Tween Bridge Solar Farm

Environmental Statement Appendix 7.9: Natural England Discretionary Advice Note – December 2024

Discretionary Advice Service (Charged Advice) UDS-A017176

Development proposal and location: EN010148 Tween Bridge Solar Farm, land to the east of Thorne & west of Ealand, South Yorkshire.

Figure 1: Non Breeding Bird Mitigation Plan

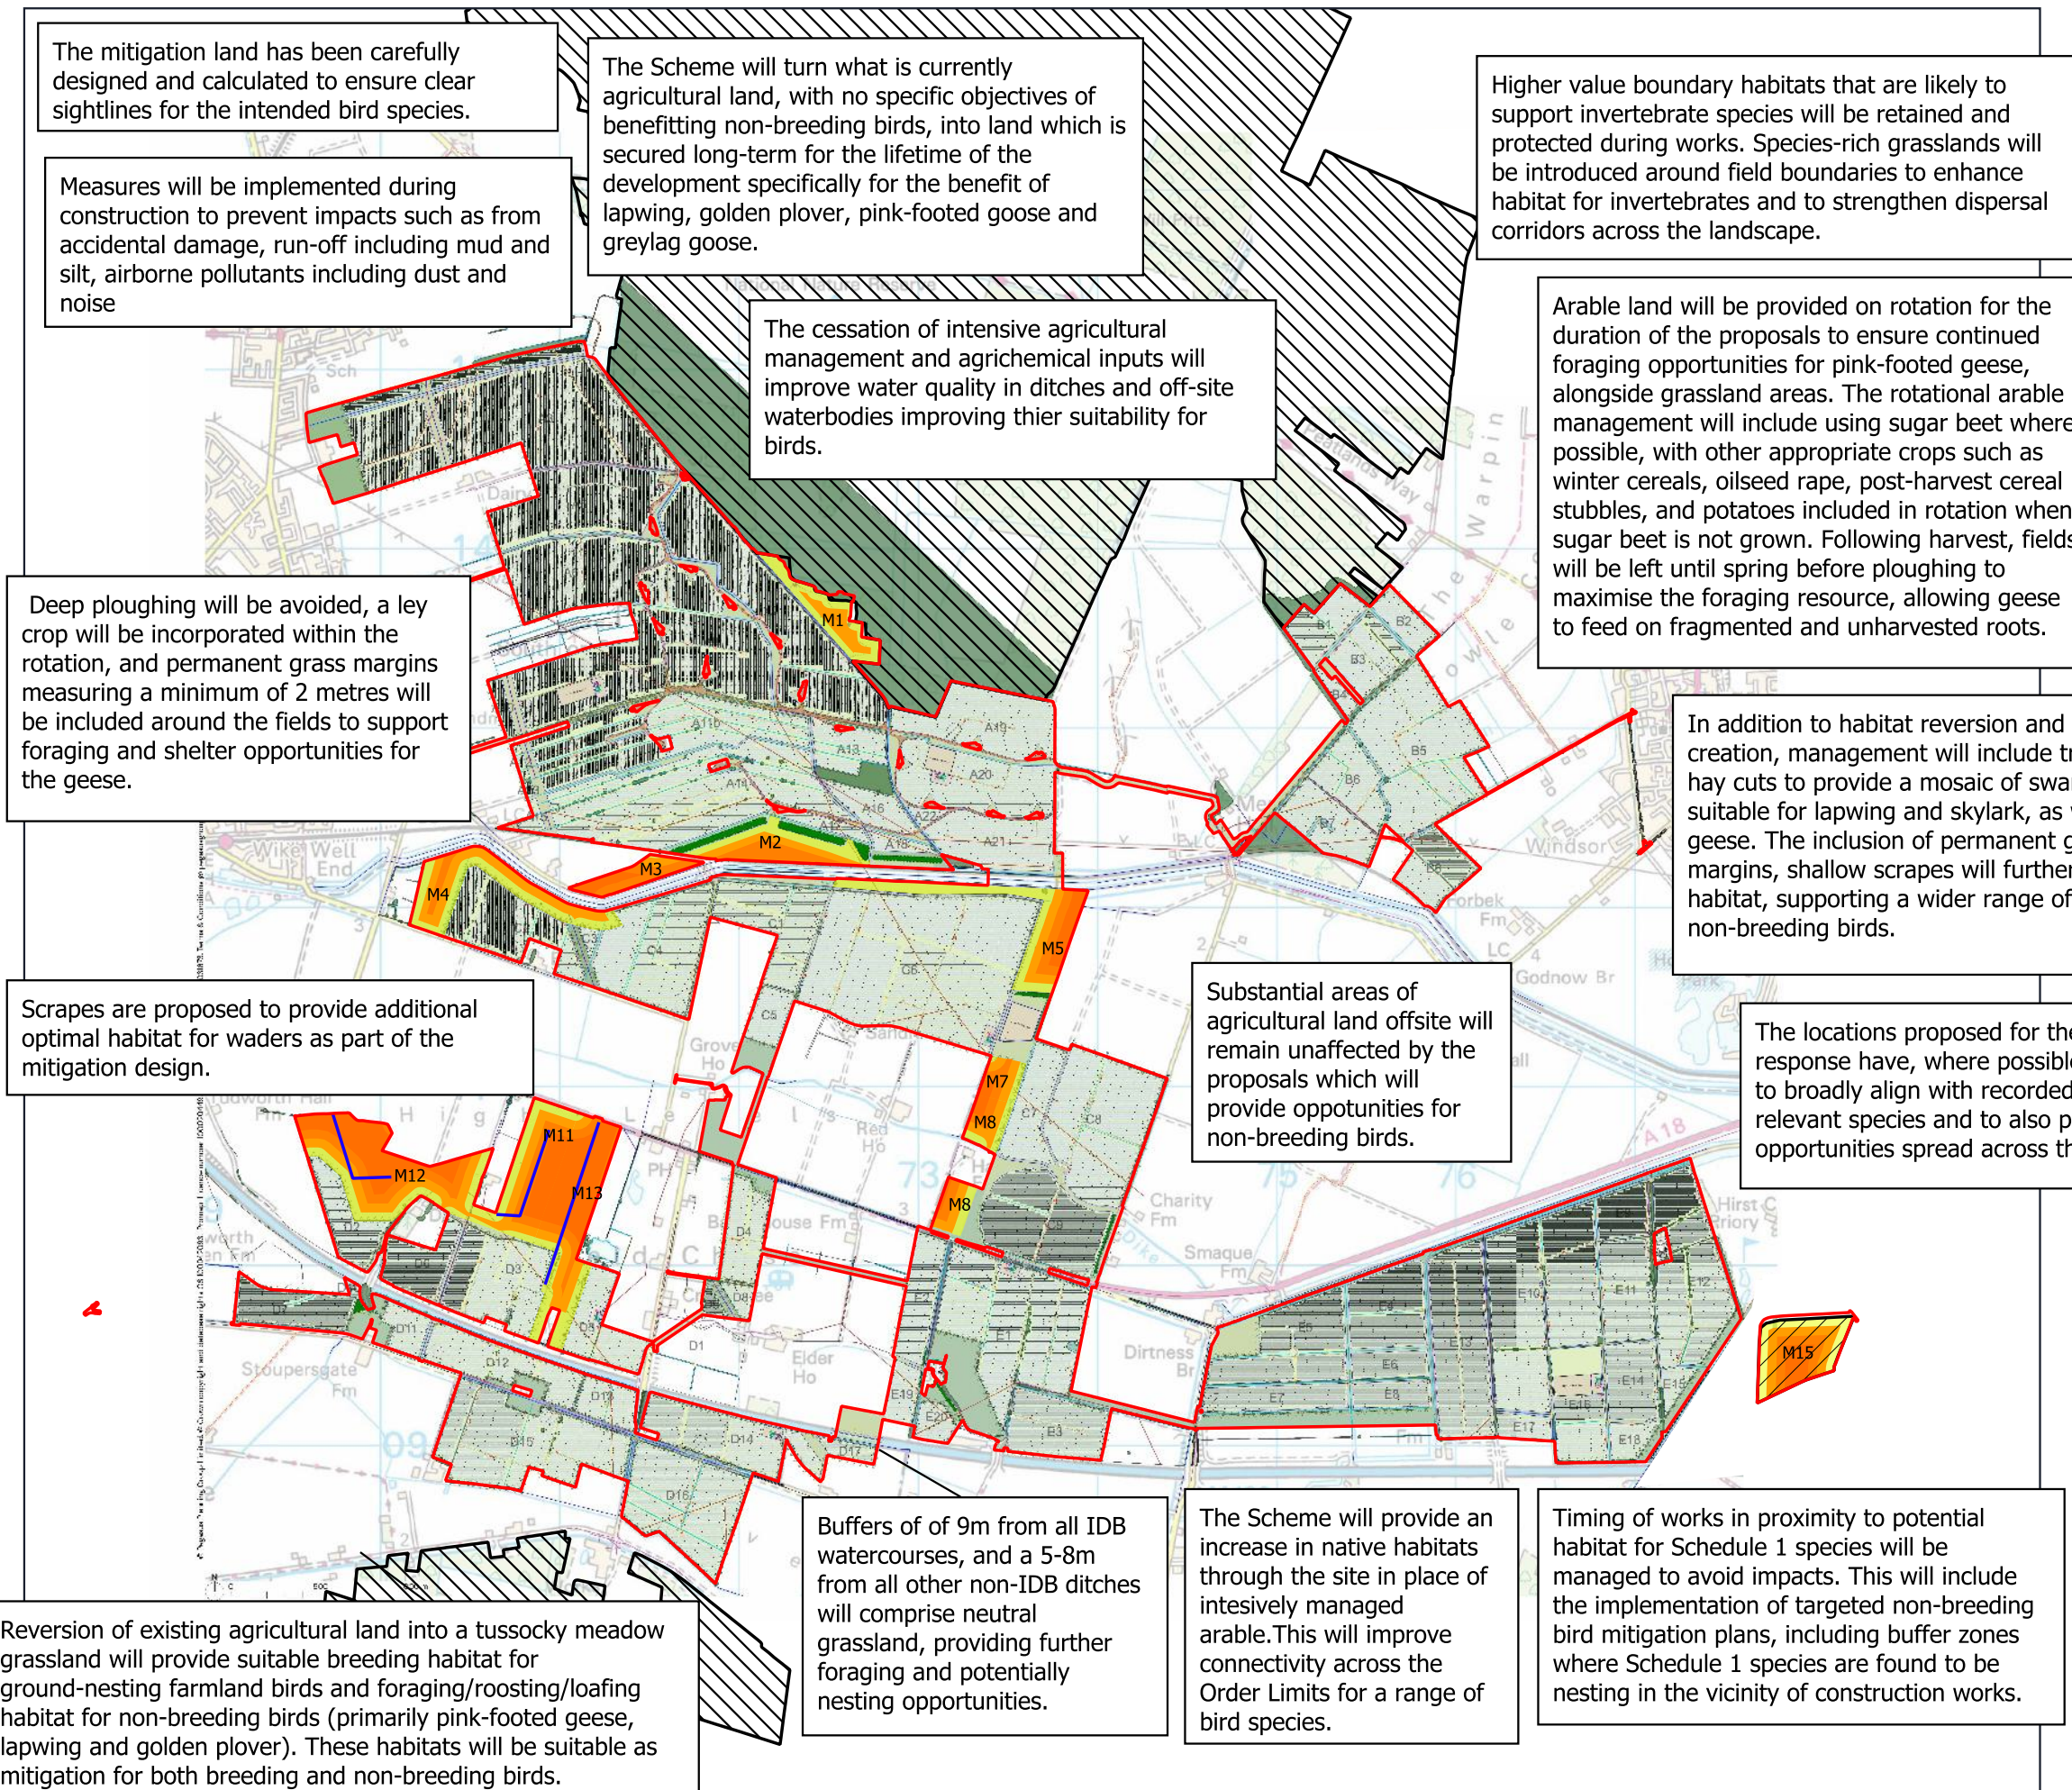
Overall, Natural England welcomes the proposed outline approach to grassland creation for waders (lapwing and golden plover), based on the information provided to date. We welcome that *“the locations proposed for the mitigation response have, where possible, been chosen to align with recorded locations of the relevant species (Appendix 1).”* It is helpful to see the baseline usage of the proposed mitigation areas in Table 2. However, further assessment is required of the capacity of the proposed mitigation areas to support the required number of birds to mitigate for impacts associated with the proposals. As stated above, this should be underpinned by an appropriate assessment of the impacts to the Humber Estuary designated sites, informed by non-breeding bird survey data from Year 2 (2023/24) and previously requested updates to the PEIR Technical Appendix 07.3: Non-Breeding Bird Survey Report.

We note the justification provided in Section 1.5 of the Mitigation Strategy that waders and pink-footed geese will not compete for foraging resources due to their differing foraging/habitat requirements. Natural England acknowledges that, in theory, both waders and geese can be accommodated as they do not compete with each other for food. However, in practice, management to maximise the food for one group might impact the other. For example, if the aim is to maximise the amount of grass for geese, then a dense even sward might hinder the waders' ability to get to soil invertebrates. Therefore, ideally the mitigation area would be larger than would be required for either one group (but not adding the two area requirements together as the two groups are not in competition and are being accommodated on the same land) so that suitable habitat types for each species can be provided. The inclusion of scrapes and muddy areas would be of particular benefit to waders.

We advise that consideration is also given to the foraging preferences of pink-footed geese in the mitigation design. Pink-footed geese are generally more likely to feed on arable land with high levels of carbohydrates than grassland, particularly earlier on in the winter season. They tend to preferentially feed on sugar beet tops, then winter cereal crops, oil seed rape or post-harvest cereal stubbles. Therefore, we would encourage consideration of the incorporation of areas of suitably managed winter crop rotation for pink-footed goose (including sugar or fodder beets, where possible), in addition to the grassland areas.

The connectivity of mitigation areas is important. For the provision of grassland, one or two larger areas is generally preferable to a fragmented design which spreads the mitigation areas throughout the site. Consideration should also be given to whether these proposed fields would adequately function in the context of surrounding proposed solar infrastructure. Golden plover and lapwing rely on open vistas to forage. As a result, if an existing smaller field becomes enclosed by infrastructure, the suitability of the field for these species may diminish. Therefore, Natural England generally advises that an undeveloped / undisturbed 150m buffer around the core mitigation areas is secured to ensure continued effective functioning of the mitigation area. If solar panels are proposed to be situated in the 150m buffer area, evidence should be presented to determine whether the siting of the panels will affect the usage of the core mitigation area by birds. If sufficient evidence is not available, we would continue to recommend that a 150m buffer free from solar infrastructure is used.

Natural England would welcome continued engagement on the proposed design and management of Parcel 1 to provide suitable mitigation for Humber Estuary SPA/Ramsar/SSSI wading birds, alongside water management improvements for Thorne & Hatfield Moors SPA/Thorne Moor SAC/SSSI. This is considered to be an important opportunity for Nature Recovery in the area.

We recommend that a wet grassland scheme with ditch raising and water level management would be the most suitable mitigation approach in this location. Natural England would also encourage suitable removal of tree cover at the edge of the moors to improve suitability of this area for wading birds. As above, the assessment will need to adequately demonstrate suitable carrying capacity, management and monitoring of this area for the relevant wading bird species.

Please confirm whether the mitigation plans for Parcel 1 include the current arable habitat only. It appears that some sections of the wider parcel are within the designated site boundary. Therefore, habitat within the designated site boundary cannot be considered towards the delivery of mitigation for loss of functionally linked land. Suitable habitat enhancement within this area may be possible; however, this would need to be delivered outside the HRA mitigation process for loss of functionally linked land.
